**Sikh Grammar School Rouse Hill (SSD-9472)
Request for Additional Information**

I refer to State Significant development application for the Sikh Grammar School Rouse Hill (SSD-9472). After careful consideration, the Department is requesting that you provide the following additional information:

CONSTRUCTION STAGE 4 - SITE PLAN
ESTIMATED COMPLETION JAN 2030

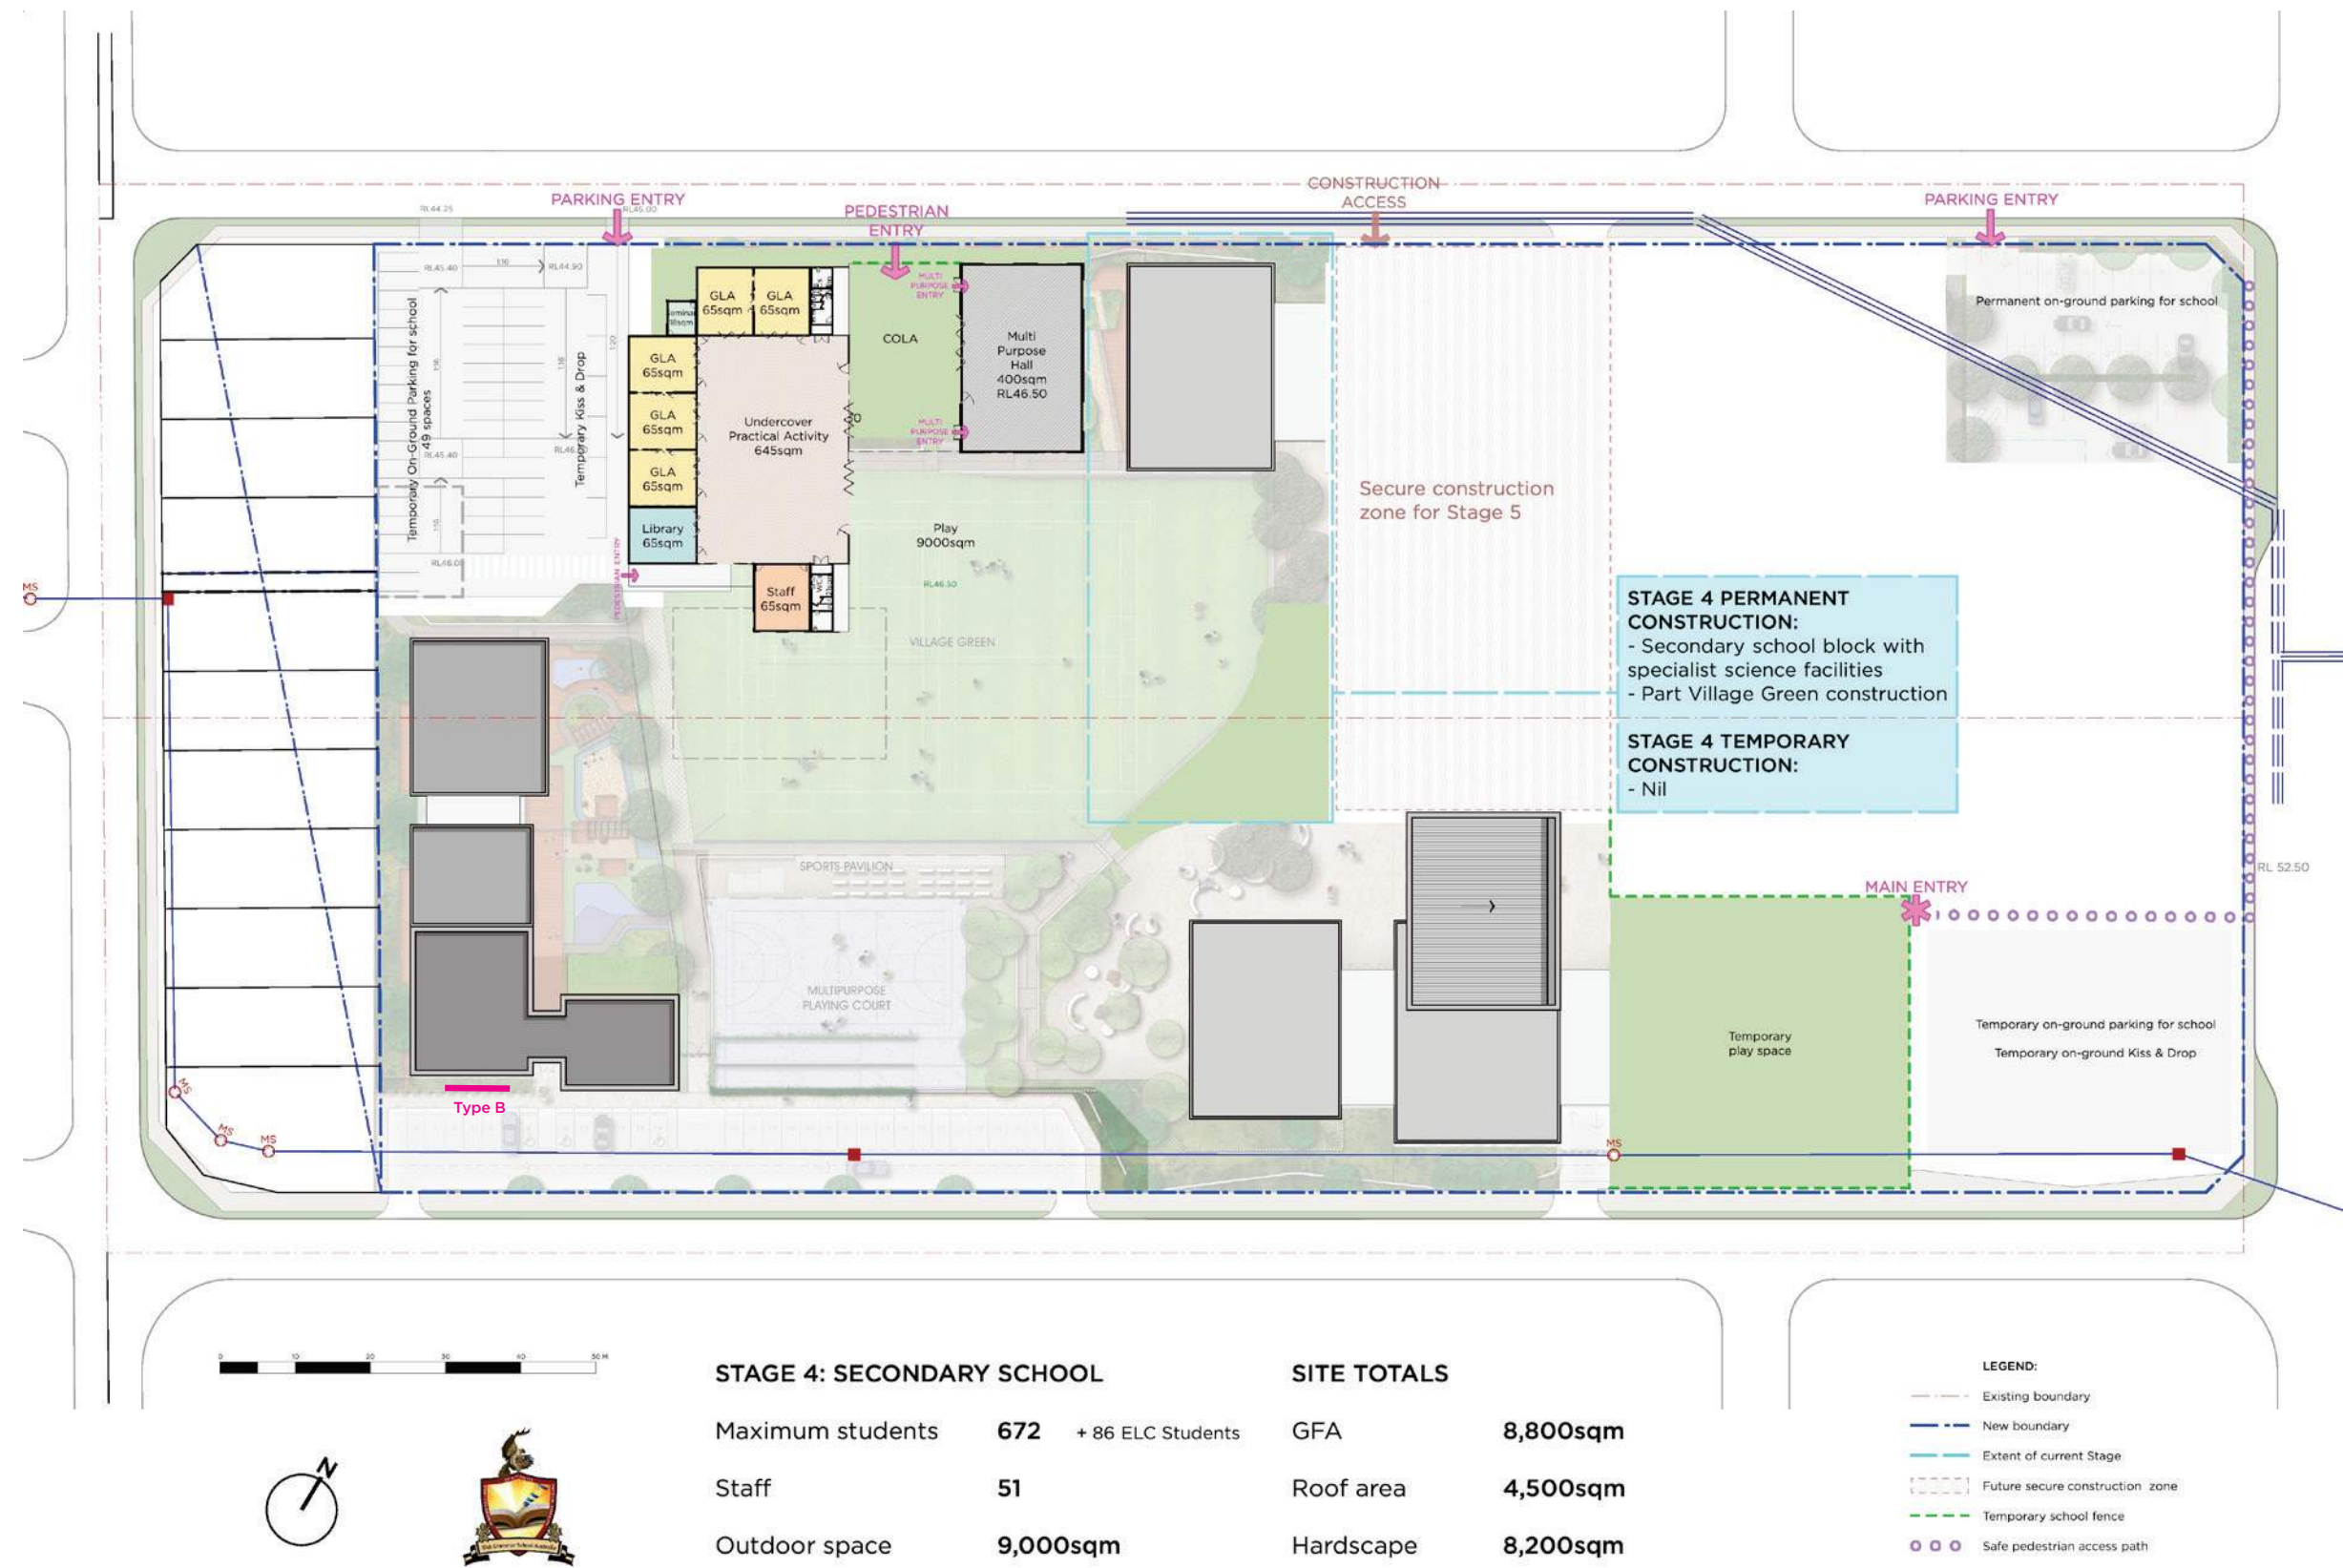
The Department notes that the staging plans submitted by PMDL Architects in the Architectural Design Report currently does not match the Traffic Report (Table 4). As an example:

- the plan for Stage 4 shows an additional 40 on ground spaces and 10 drop-off / pick-up spaces at the south-eastern corner. This is not reflected in the traffic report.
- the traffic report states that the under-ground drop-off / pick-up area would be delivered in Stage 5 whereas the Staging plan says it would occur in Stage 7.

CONSTRUCTION STAGE 5 - SITE PLAN
ESTIMATED COMPLETION JAN 2023

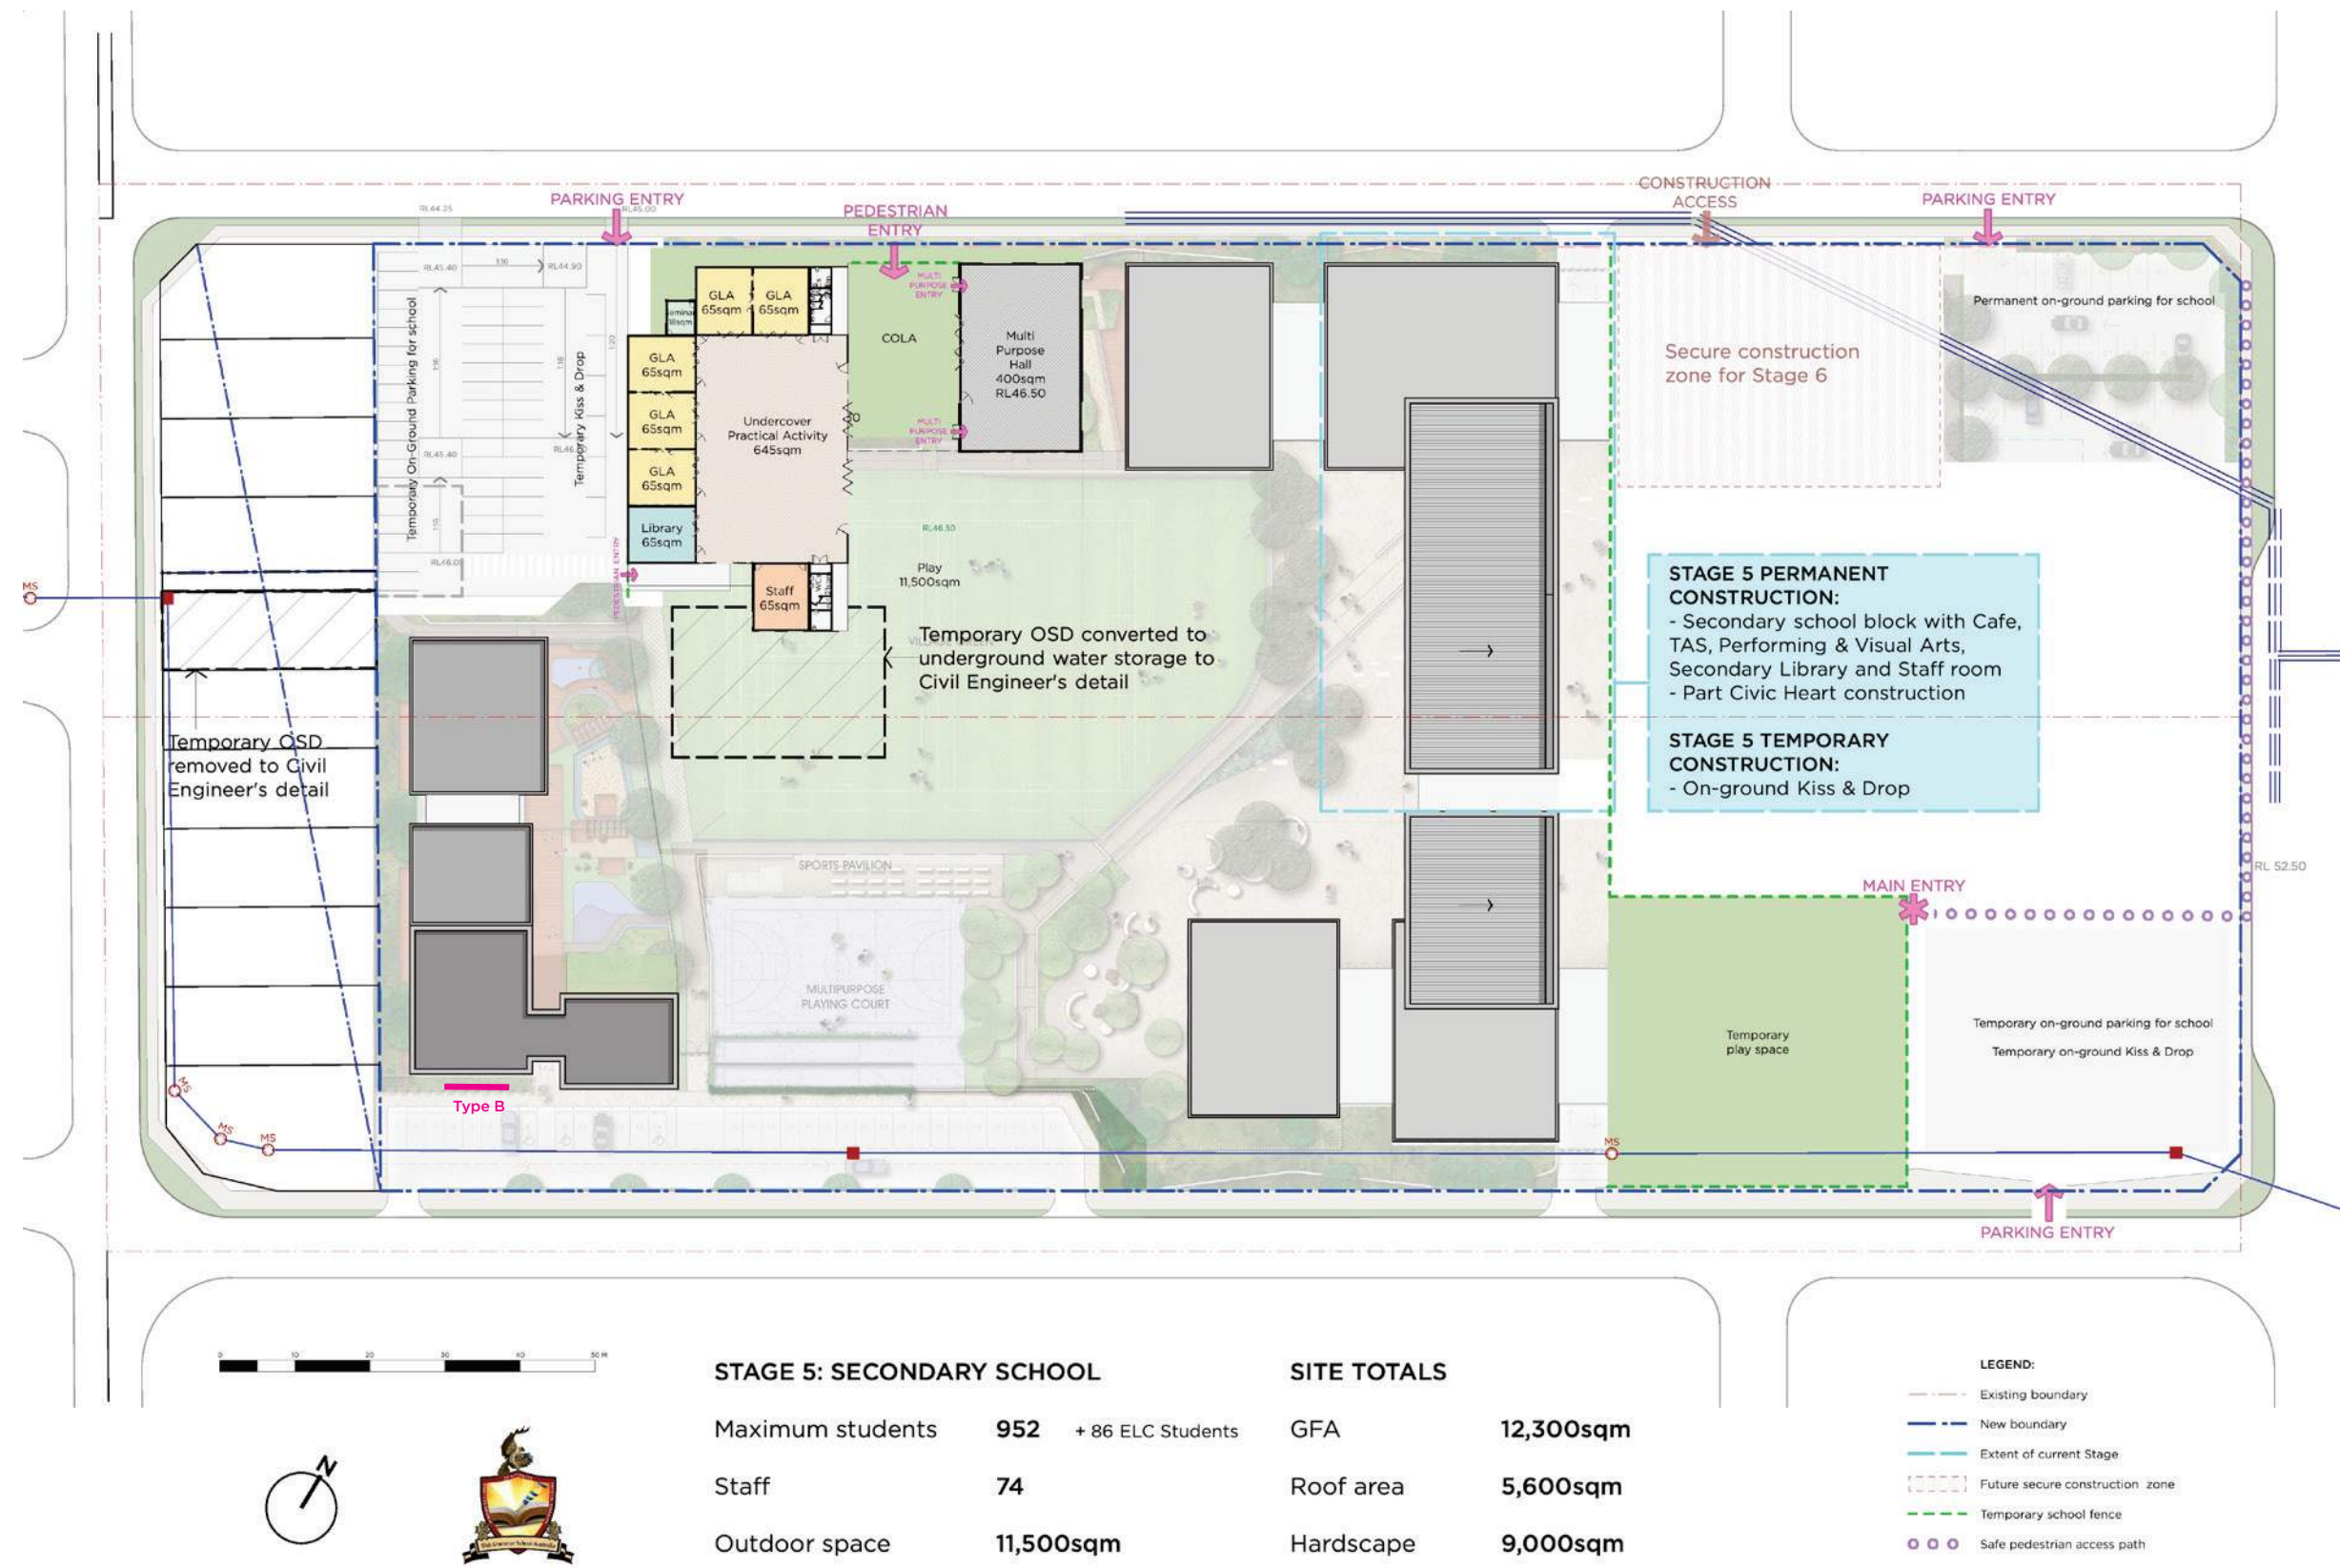
The Staging Table in the Table 4 of the Traffic Report notes that on-site drop-off / pick-up is proposed in **Stage 5** of the development and then an underground car park in **Stage 7**. However, the proposal would accommodate up to 900 school students before that. No information has been provided in the Traffic Report to indicate how many temporary drop-off / pick-up spaces are provided within the site till the time the underground carpark is delivered.
